**From:** Mark Warwick  
**Sent:** 06 March 2019 11:33  
**To:** Simon Davis  
**Cc:** Planning.Responses  
**Subject:** AW/279/18/RES

**Planning Application Ref:** AW/279/18/RES

**Location:** 261 Aldwick Road, Aldwick, PO21 3QU

**Description of works:** Application for approval of reserved matters following outline approval AW/43/18/OUT for the demolition of existing dwelling & erection of two pairs of semi-detached houses & associated works

Tree Retention and Protection Plan

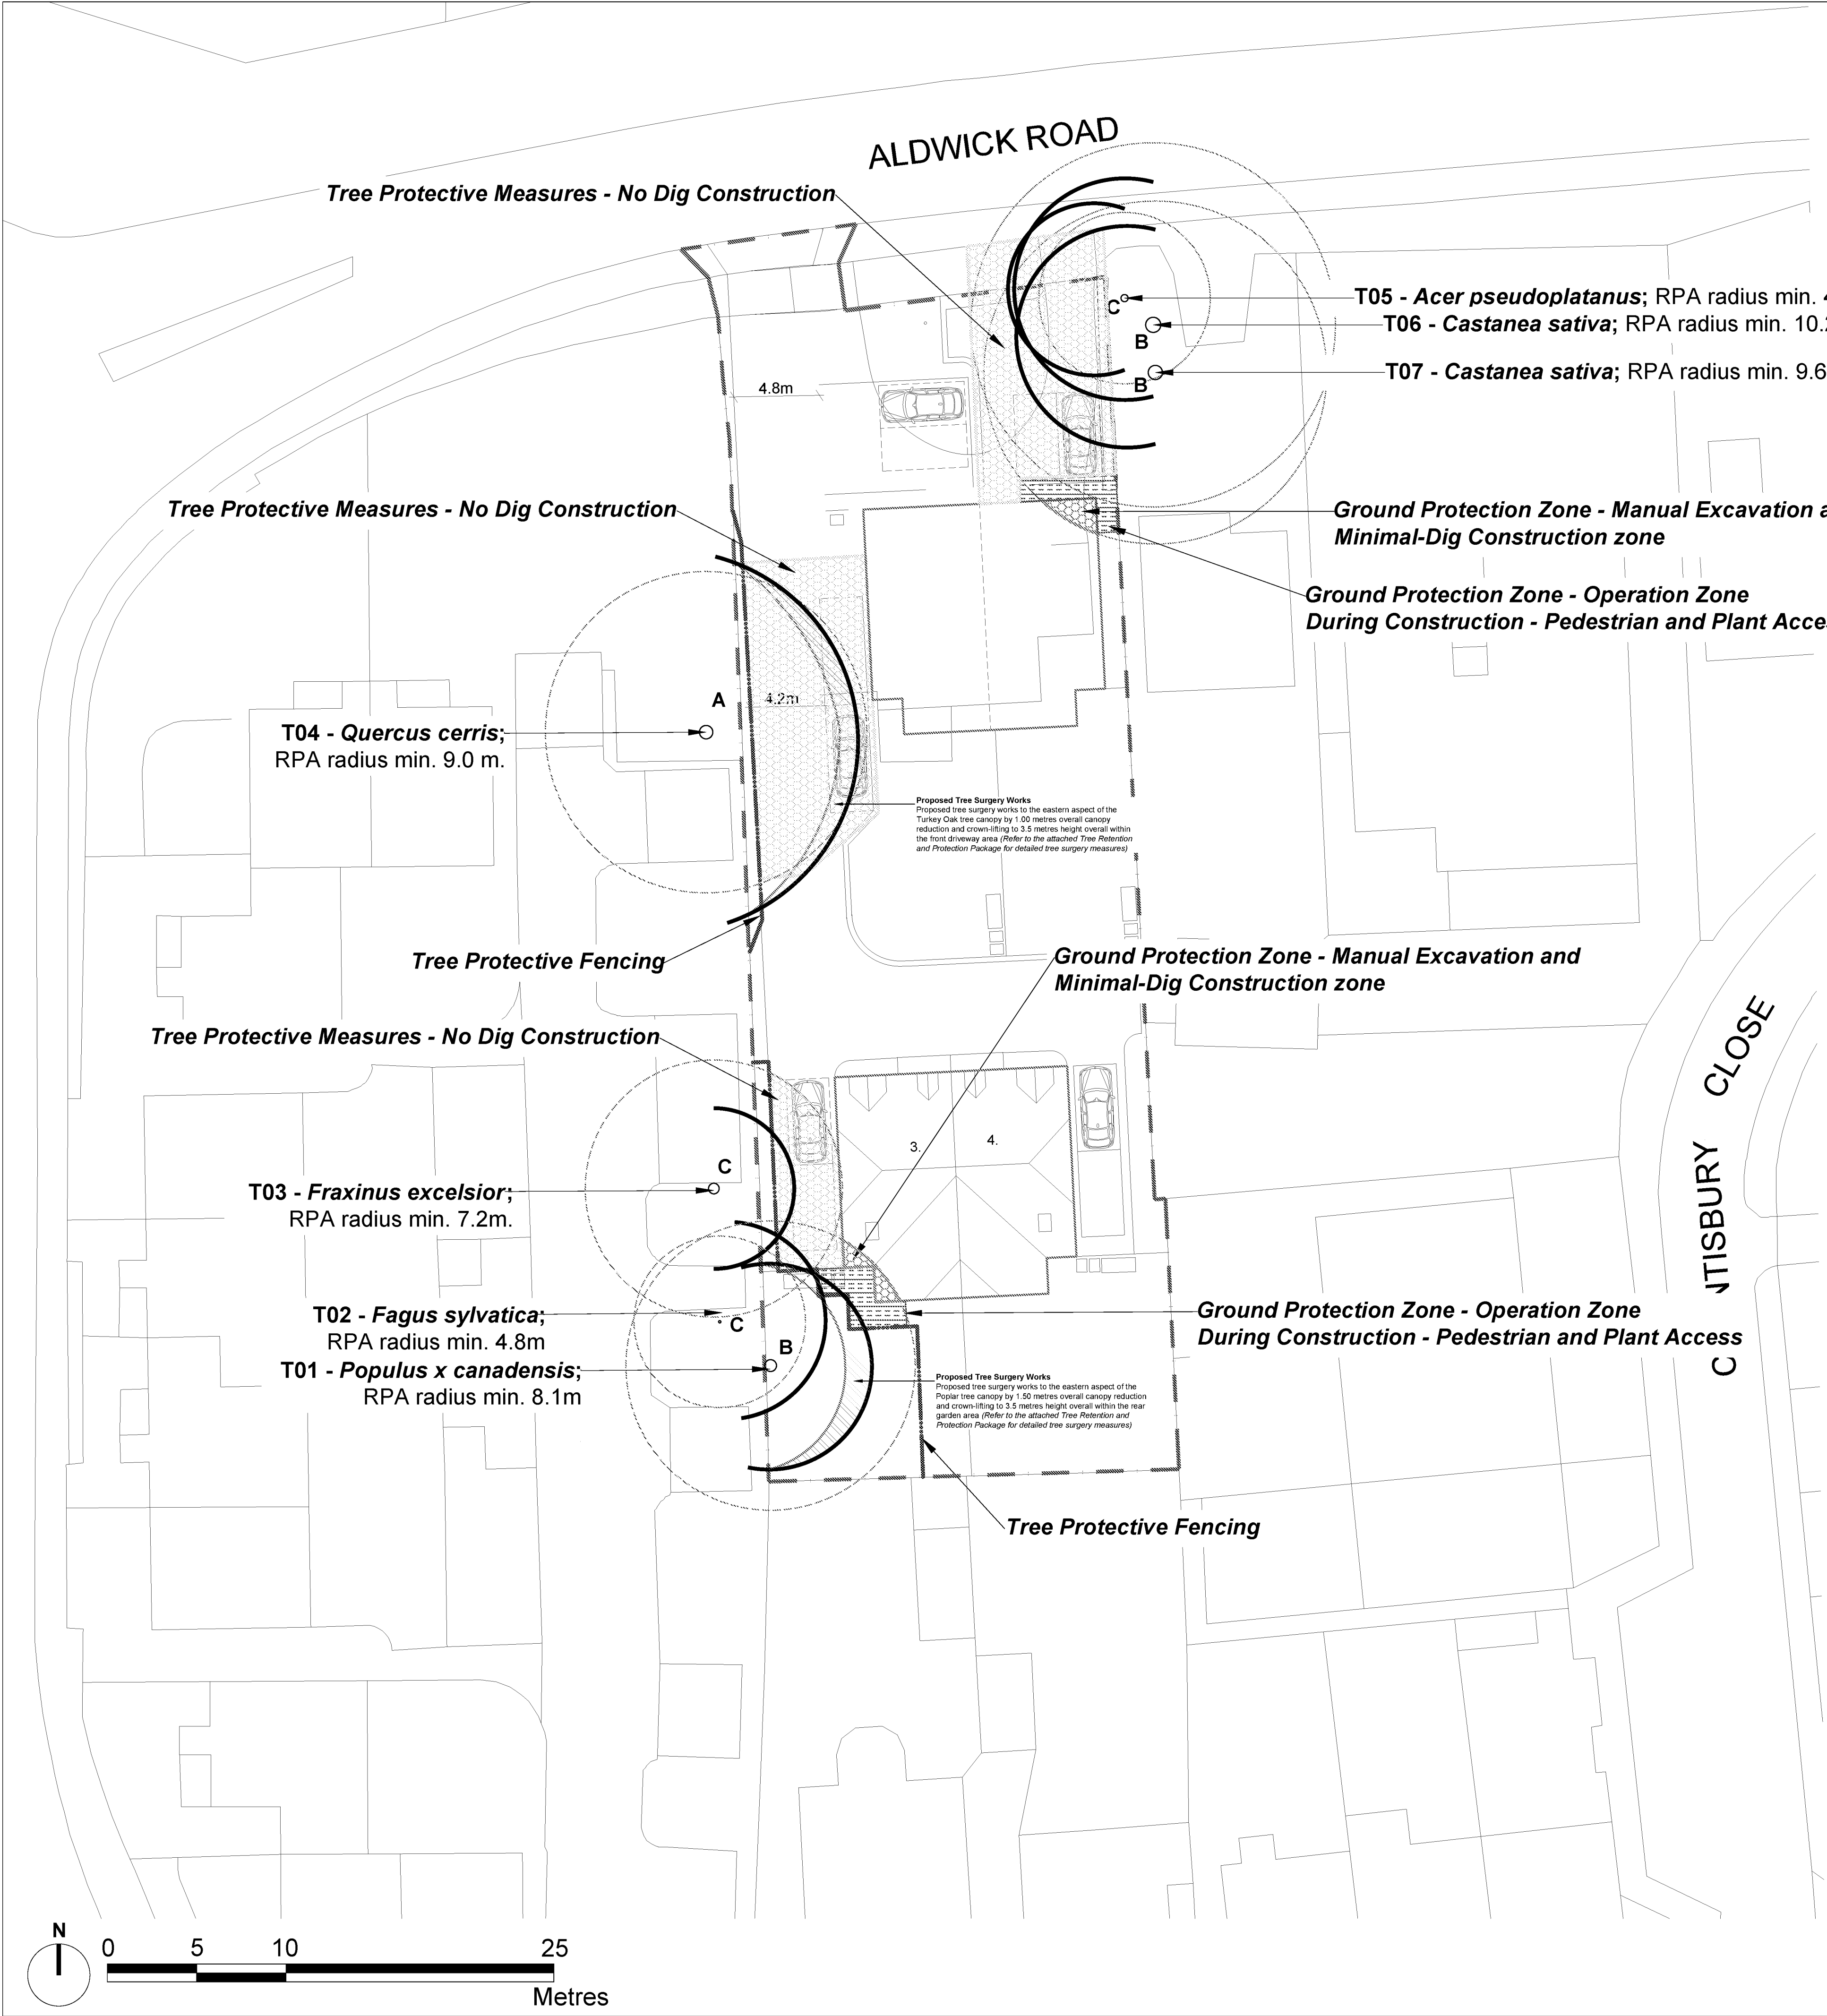
- I remain concerned with the 'Minimal-dig' Construction methodology as described in the AIA/AMS, 21/June/18, Rev 01 (p13, para. 4.29) which states that existing soft ground layers within Root Protection Areas are to be removed so as to provide the necessary construction depth and to meet with existing hard surface levels. This is not a 'No-dig' Construction, which is the only methodology I could support alongside these valuable trees. The AIA/AMS and TPP have been revised, with satisfactory reference to and improved description of 'No-dig' solution/methodology.

- The extent and depth of proposed ground level alteration has not been provided in detail or shown on any cross-section drawing, so we cannot be sure these trees will not suffer significant damage. Is it not possible to 'build up' soil levels slightly to achieve an acceptable platform, that better respects the trees? This remains a significant and outstanding issue. While the applicant suggests *'the proposed levels of the access driveways is a detailed civil engineering exercise which should be conditioned prior to commencement of development'* - I consider this to be unacceptable. Given the complexities of developing this site I would wish to have all outstanding arboriculture matters resolved to my complete satisfaction up front and not left to Conditions for fear that in the event that they cannot then be proven to work we would be held hostage to the approval.

- If they can resolve the above concern to my satisfaction, by way of demonstrating how a true 'No-dig' Construction can be achieved across the site at those three areas identified on their Tree Retention and Protection Plan, dwg.no.LLD1245-ARB-DWG-002, Rev02, 21.06.18 and clearly write this into their AIA/AMS and to correspond with the TPP; then I would be able to remove my objection and recommend approval subject to the following conditions being applied:

- Before the site is occupied or any machinery is introduced to the site or demolition work or construction work or alterations to existing ground levels takes place a **PRE-COMMENCEMENT Site Meeting** is to take place between the Arun DC Tree Officer and the Arboricultural Expert representing the site owners – at this meeting all protective fencing will be inspected along with ground protection measures – they will be assessed to verify that they are ‘Fit for Purpose’ as required under British Standard 5837:2012 and have been erected and positioned exactly as shown on the **Tree Retention and Protection Plan ref: LLD1425-ARB-DWG-002, Rev02, 21.06.18.**
